Heckington Fen Solar Park

EN010123

Cover Letter

Change Notification (our document reference – PreExA.CL.CN.v1)

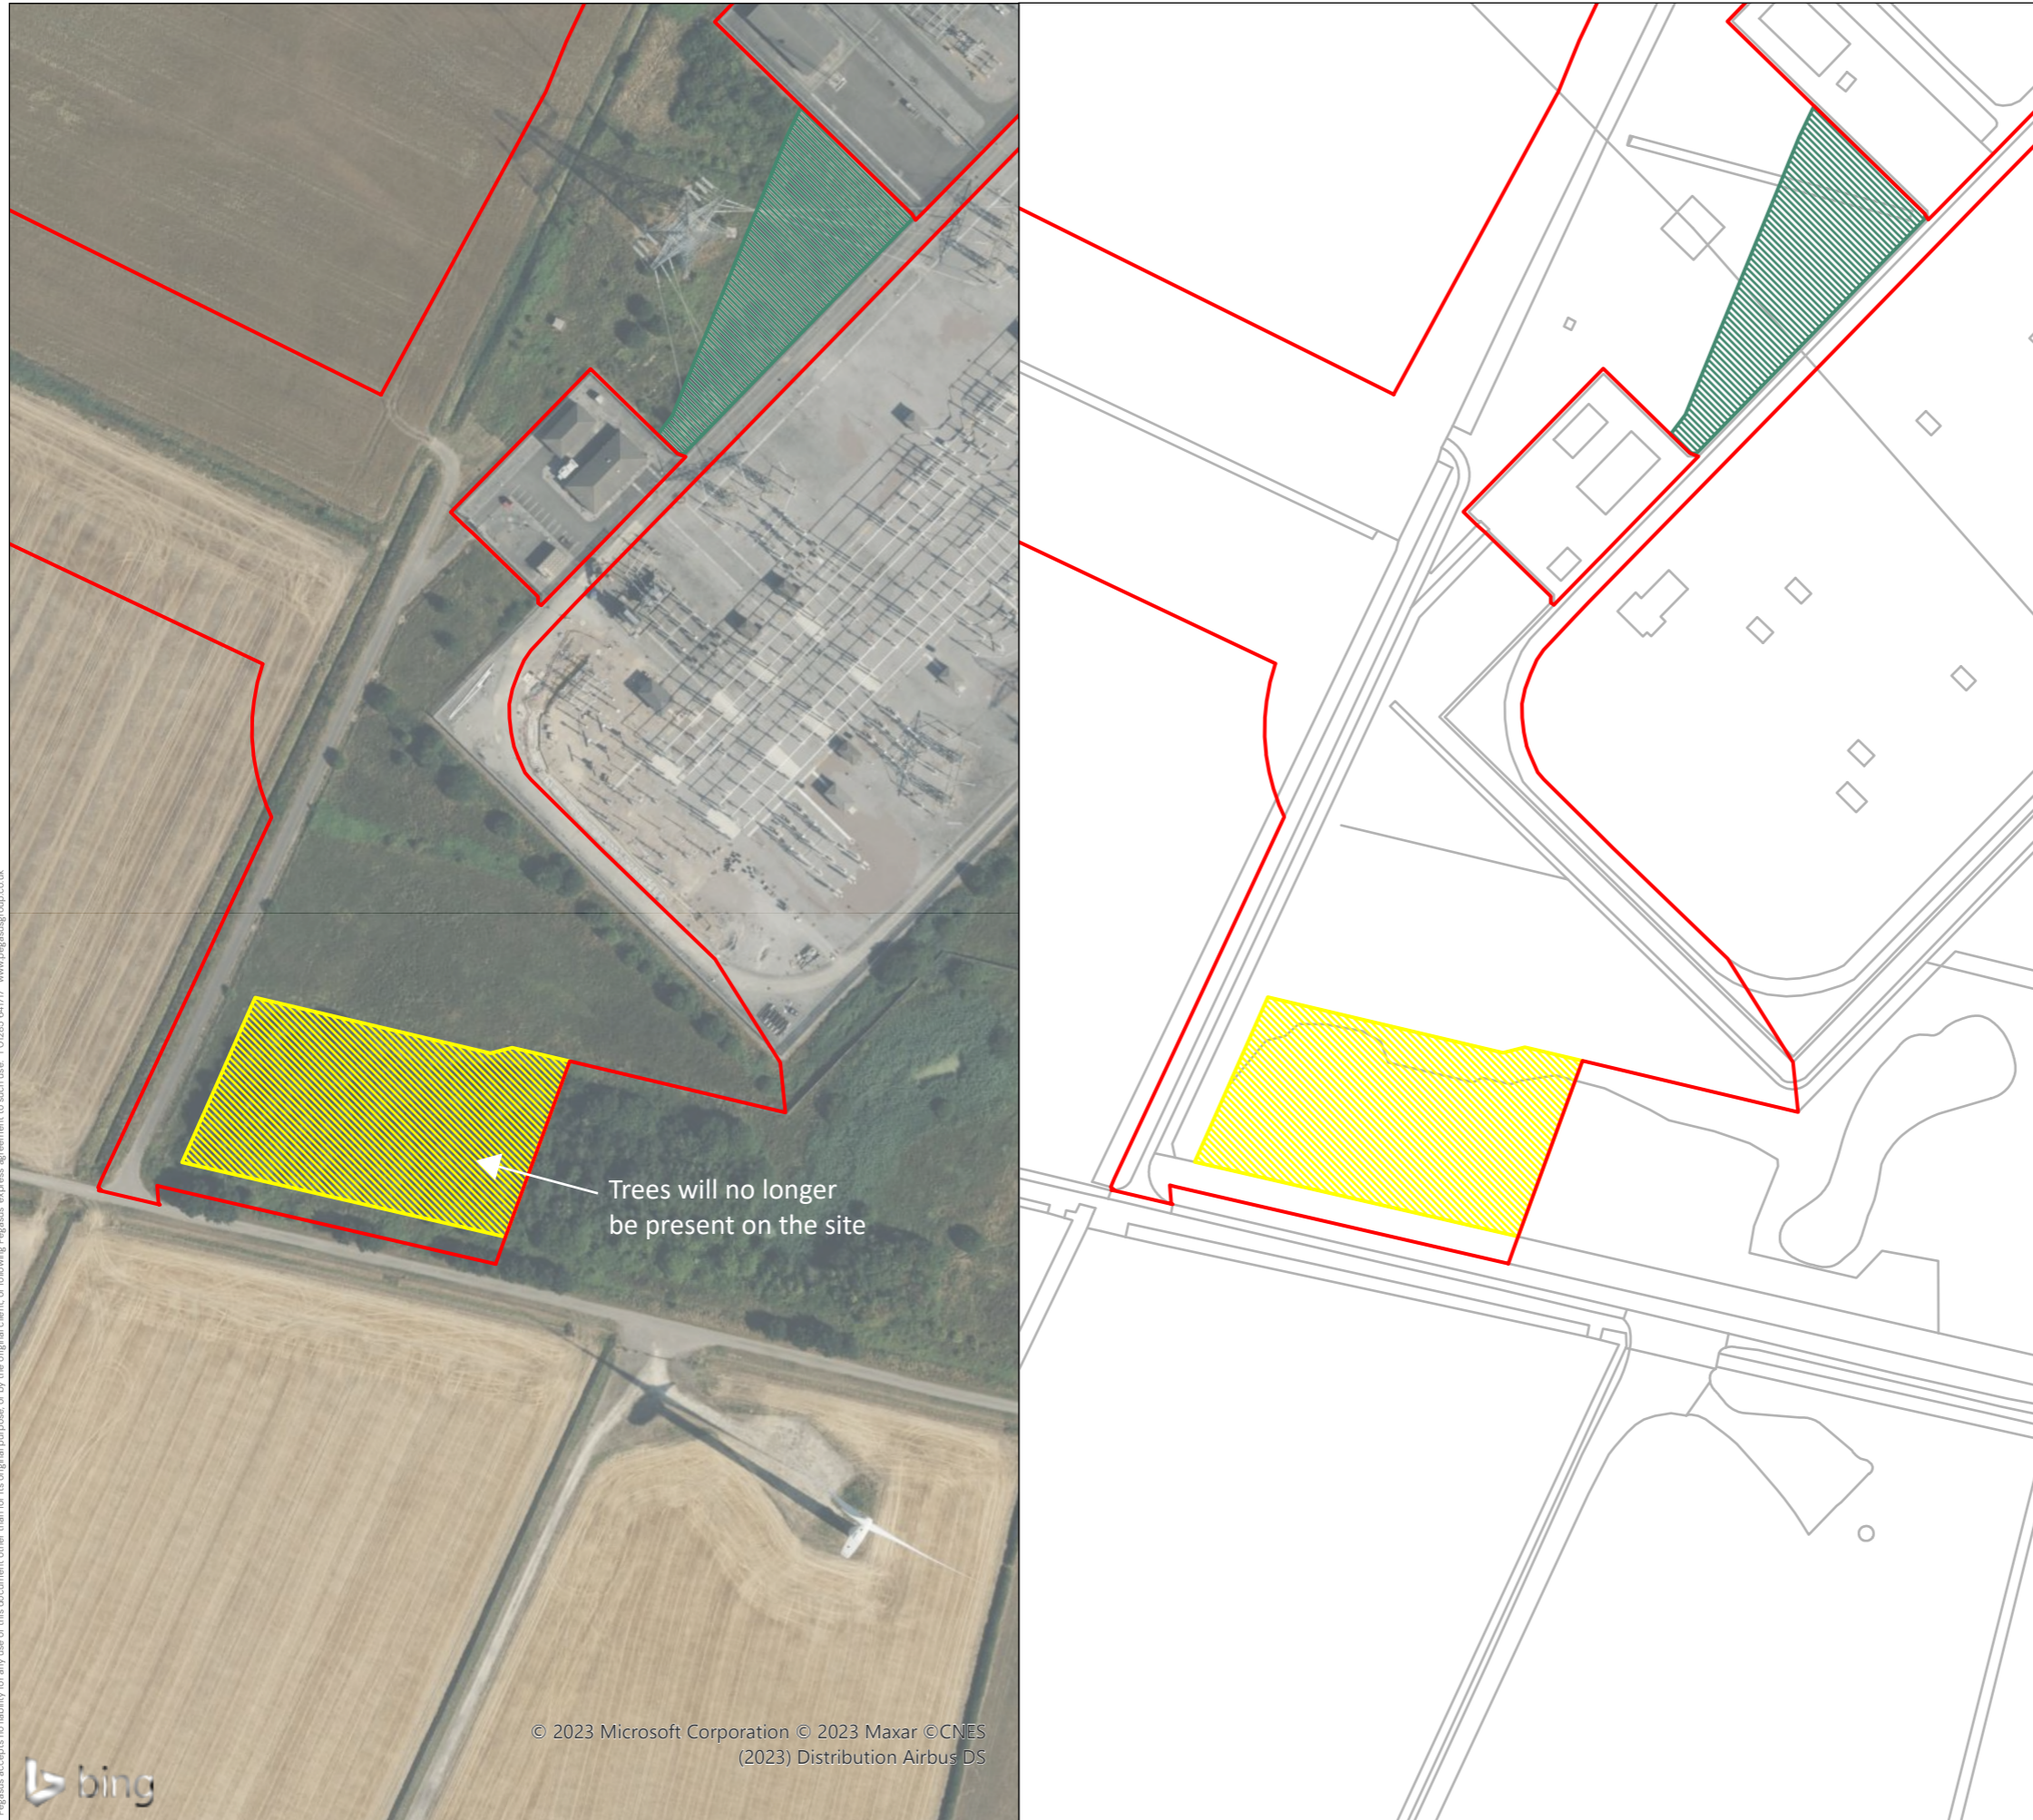
The proposed change will result in the removal of a section of established tree plantation in the location to the south of the Bicker Fen Substation. The plantation trees were planted for compliance with a condition for the grant of planning permission for the Bicker Fen Substation which was approved in 2005 (under Boston Borough Council reference B/05/0046).

The Applicant's preliminary assessment is that replacement tree planting may not be possible because of the land taken by the Additional Works as they do not leave sufficient land available for planting. However that preliminary assessment also considers that the removal of the planting will not give rise to any significant visual or landscape impacts. The ecological impact

- Proposed Order Limits
- AW1
- AW2
- Submitted DCO Order Limits

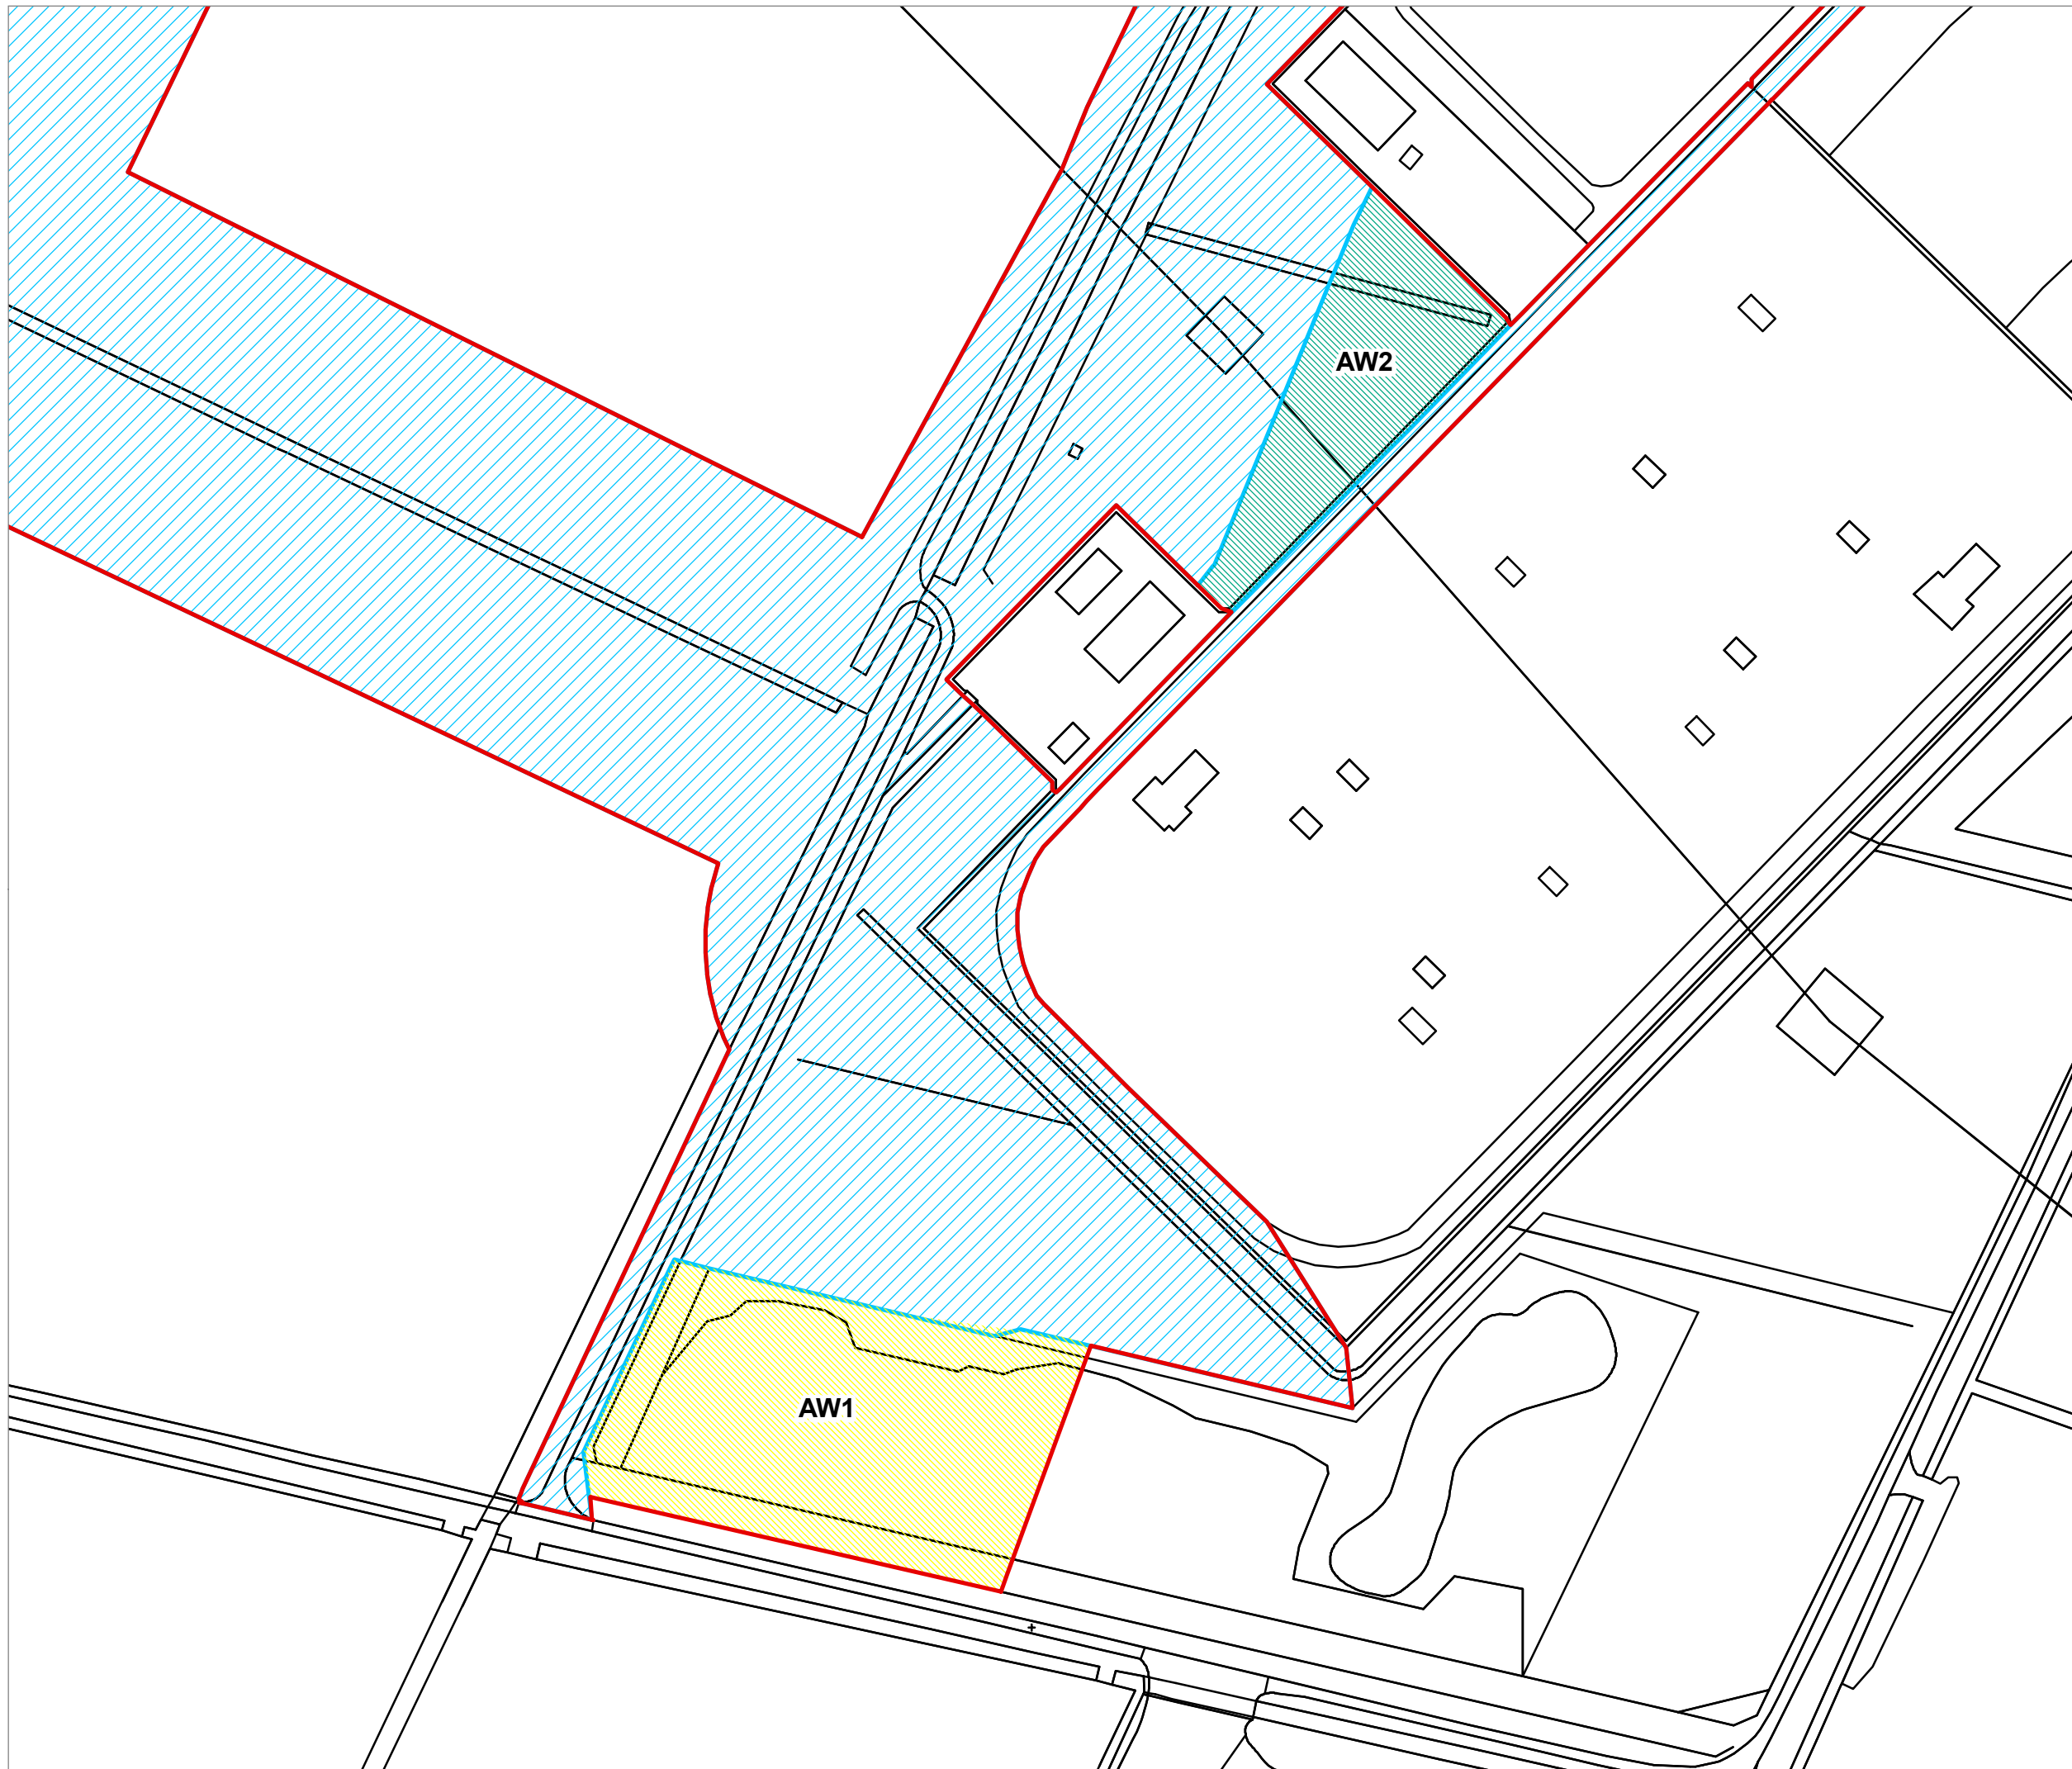
1. a new section of NGET infrastructure at the substation comprising a busbar extension including a section breaker, a bus coupler and a feeder circuit on land to the south of Bicker Fen Substation, which is owned by NGET; and
2. a new cable sealing end ("CSE") compound on land to the west of Bicker Fen Substation which is owned by NGET.

Accordingly, a larger area is needed to facilitate the Applicant's connection into the Bicker Fen Substation. The full extent of the land area covered by the change is shown in yellow and green shading on Figure 1 appended to this letter.

1. a new section of NGET infrastructure at the substation comprising a busbar extension including a section breaker, a bus coupler and a feeder circuit on land to the south of Bicker Fen Substation, which is owned by NGET ("**AW1**"); and
2. a new cable sealing end ("CSE") compound on land to the west of Bicker Fen Substation which is owned by NGET ("**AW2**").

A CSE is a connection point to transition between underground cable and above ground apparatus such as electrical bus-bars or overhead line. At Bicker Fen Substation there is a 400kV transmission tower on the western boundary of the substation site which carries overhead line circuits to West Burton. As part of facilitating the Applicant's connection, one of the West Burton circuits will be moved to terminate at a new bay that will be constructed as part of the Bicker Fen Substation extension. To achieve this, the overhead line circuit will be connected onto a new CSE to be located in the area adjacent to the tower and an underground cable run to the new bay. For this reason, the Order Limits need to be extended around the transmission tower to allow for this circuit transfer.
